**Planning Department
Transportation Development Services**

May 1, 2015

**Re: HLP Endodontics
10429 Lagrima De Oro NE
Traffic Circulation Layout**
Engineer's/Architect's Stamp dated 4-23-15 (F21-D063)

date
4-23-15
sheet
A001

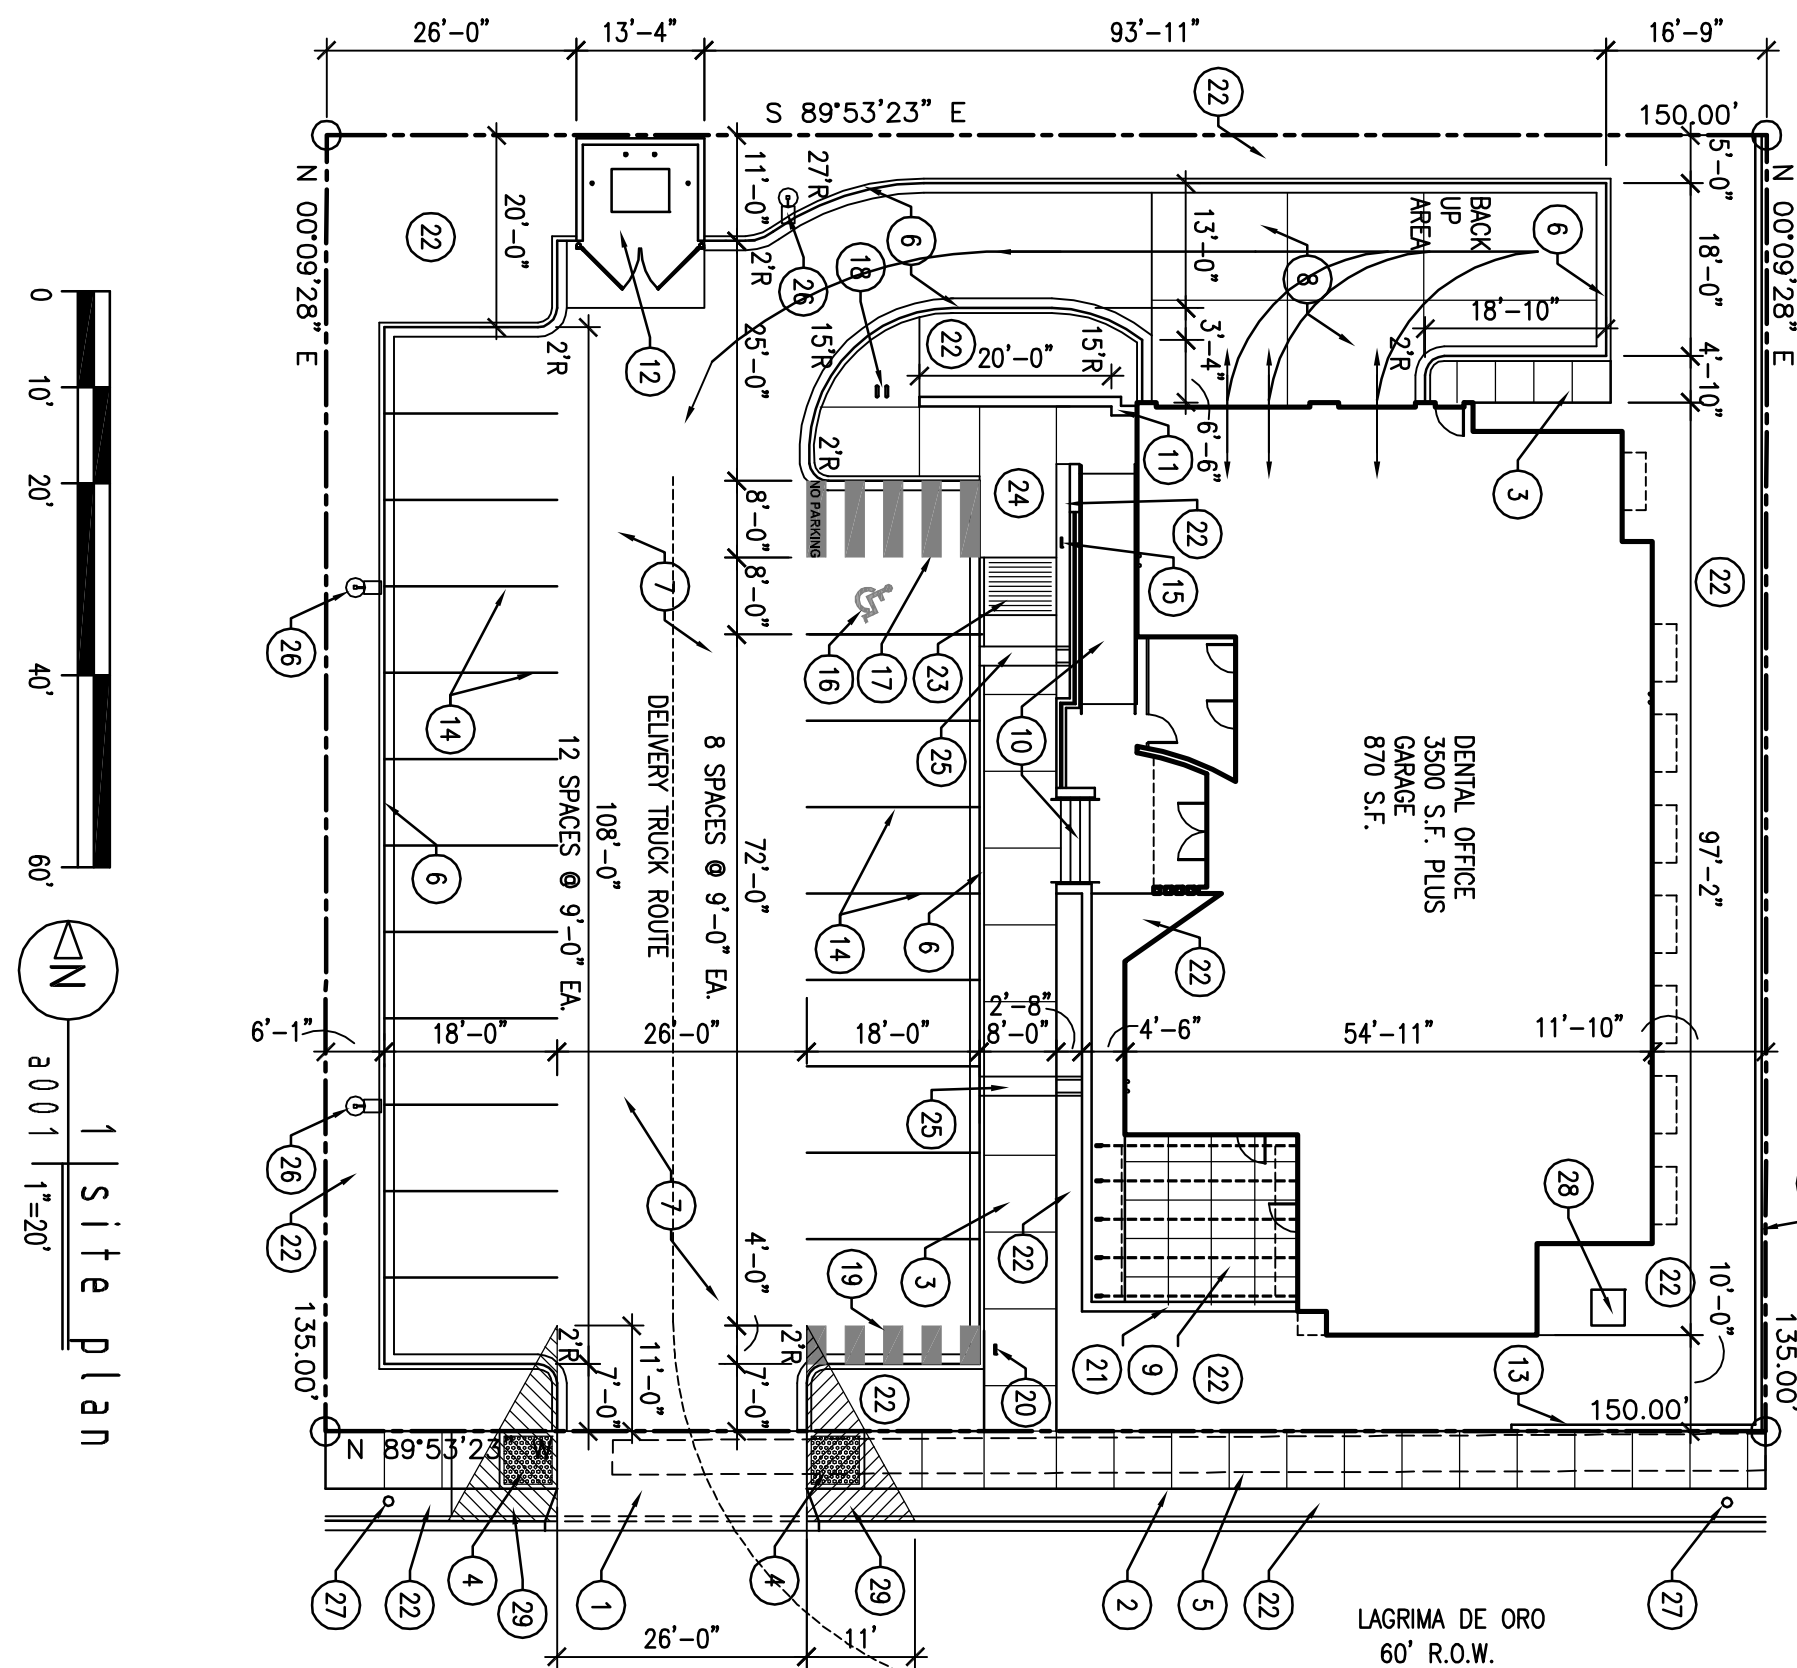
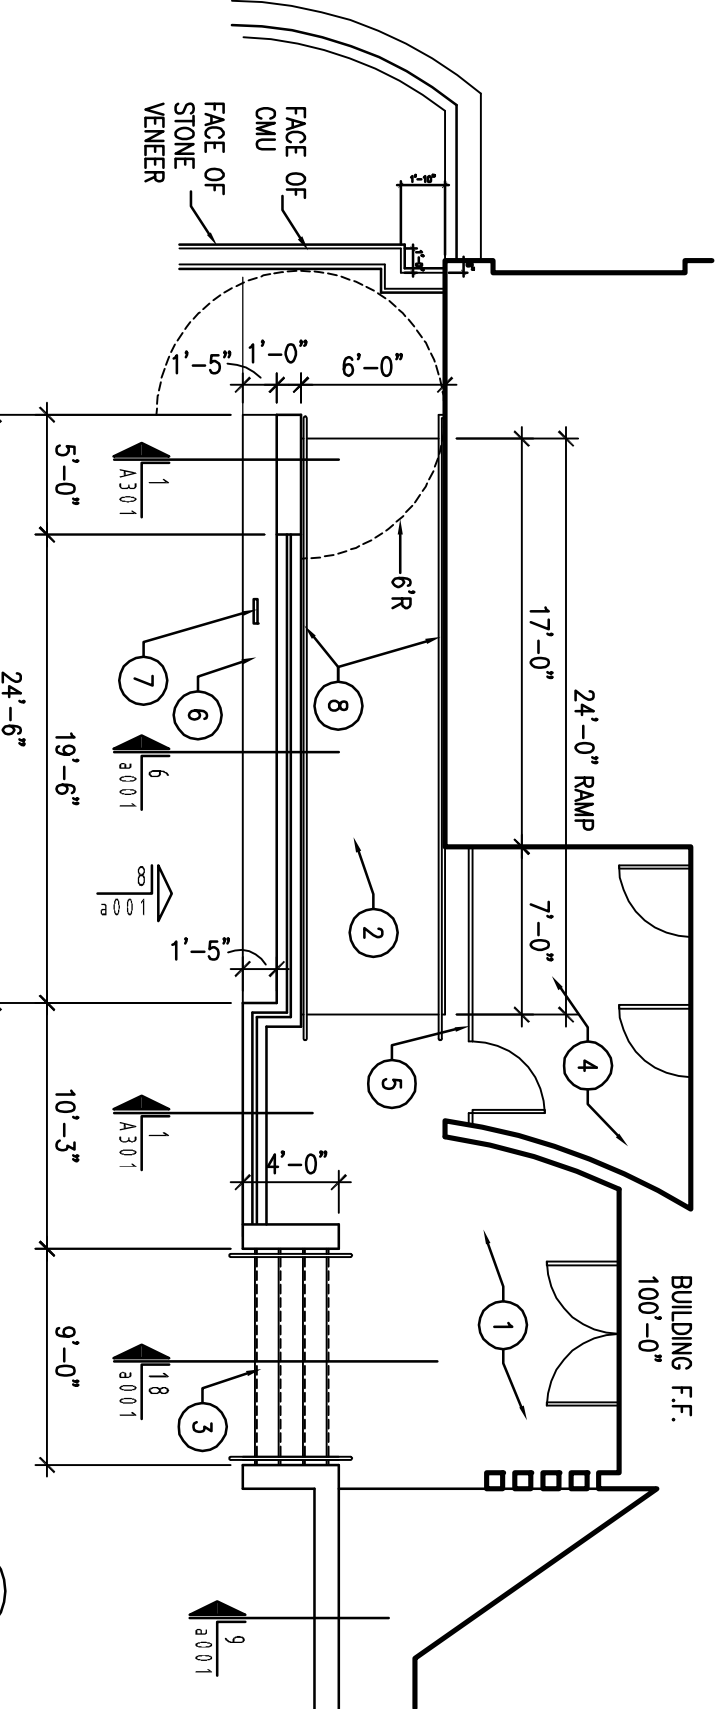
1. List the number of parking spaces required by the zoning code as well as the proposed number of parking spaces.
2. Identify the right of way width, medians, curb cuts, and street widths on Lagrima De Oro Rd.

3. Please list the width and length for all parking spaces. The parking spaces on the west end of the proposed parking lot do not show a width dimension.

4. Clearly show the location of the motorcycle parking.
5. The ADA van accessible sign must have the required language per 66-7-352.4C NMSA 1978 **"Violators Are Subject to a Fine and/or Towing."**

6. The ADA access aisle shall have the words **"NO PARKING"** in capital letters, each of which shall be at least one foot high and at least two inches wide, placed at the rear of the parking space so as to be close to where an adjacent vehicle's rear tire would be placed. (66-1-4.1.B NMSA 1978)

7. List radii for all curves shown; for passenger vehicles, the minimum end island radius is 15 feet. Landscape island radius for delivery trucks, fire trucks, etc. is 25 feet or larger. Please clarify the radii on the north end of proposed building.

8. Per the DPM, a 6 ft. wide ADA accessible pedestrian pathway is required from the public sidewalk to the building entrances. Please clearly show this pathway and provide details.

9. Per the DPM, a 6 ft. wide ADA accessible pedestrian pathway is required from the HC parking stall access aisles to the building entrances. The Handicap pathway must be a continuous 6 ft. wide. As detailed on your drawing, the handicap pathway narrows to 3 ft. 4 inches. Please design so that a 6 ft. wide pathway is provided for ADA accessibility into the proposed building.
10. Design delivery vehicle route needs to be shown.
11. Please provide a sight distance exhibit (see the *Development Process Manual, Chapter 23, Section 3, Part D.5 Intersection Sight Distance*). A Mini-Clear Sight Triangle needs to be maintained starting at the sidewalk and measuring 11 ft. on a side, as shown below.

12. Please add the following note to the clear sight triangle: "Landscaping and signage will not interfere with clear sight requirements. Therefore, signs, walls, trees, and shrubbery between 3 and 8 feet tall (as measured from the gutter pan) will not be acceptable in this area."
13. Please specify the City Standard Drawing Number when applicable. Please add COA Standard # 2425 and 2430 to Key Note No.1. Please change Key Note No. 23 to clarify that it is referring to ADA Ramp Detail No.15. Please add "(12:1 Max)" to Key Note No.2 of the Enlarged Entry Plan detail, referring to the ADA ramp.
14. Work within the public right of way requires a work order with DRC approved plans.
15. See Chapter 23, Section 6 of the City of Albuquerque *Development Process Manual*, for appropriate drive pad widths.
16. Please include two copies of the traffic circulation layout at the next submittal.
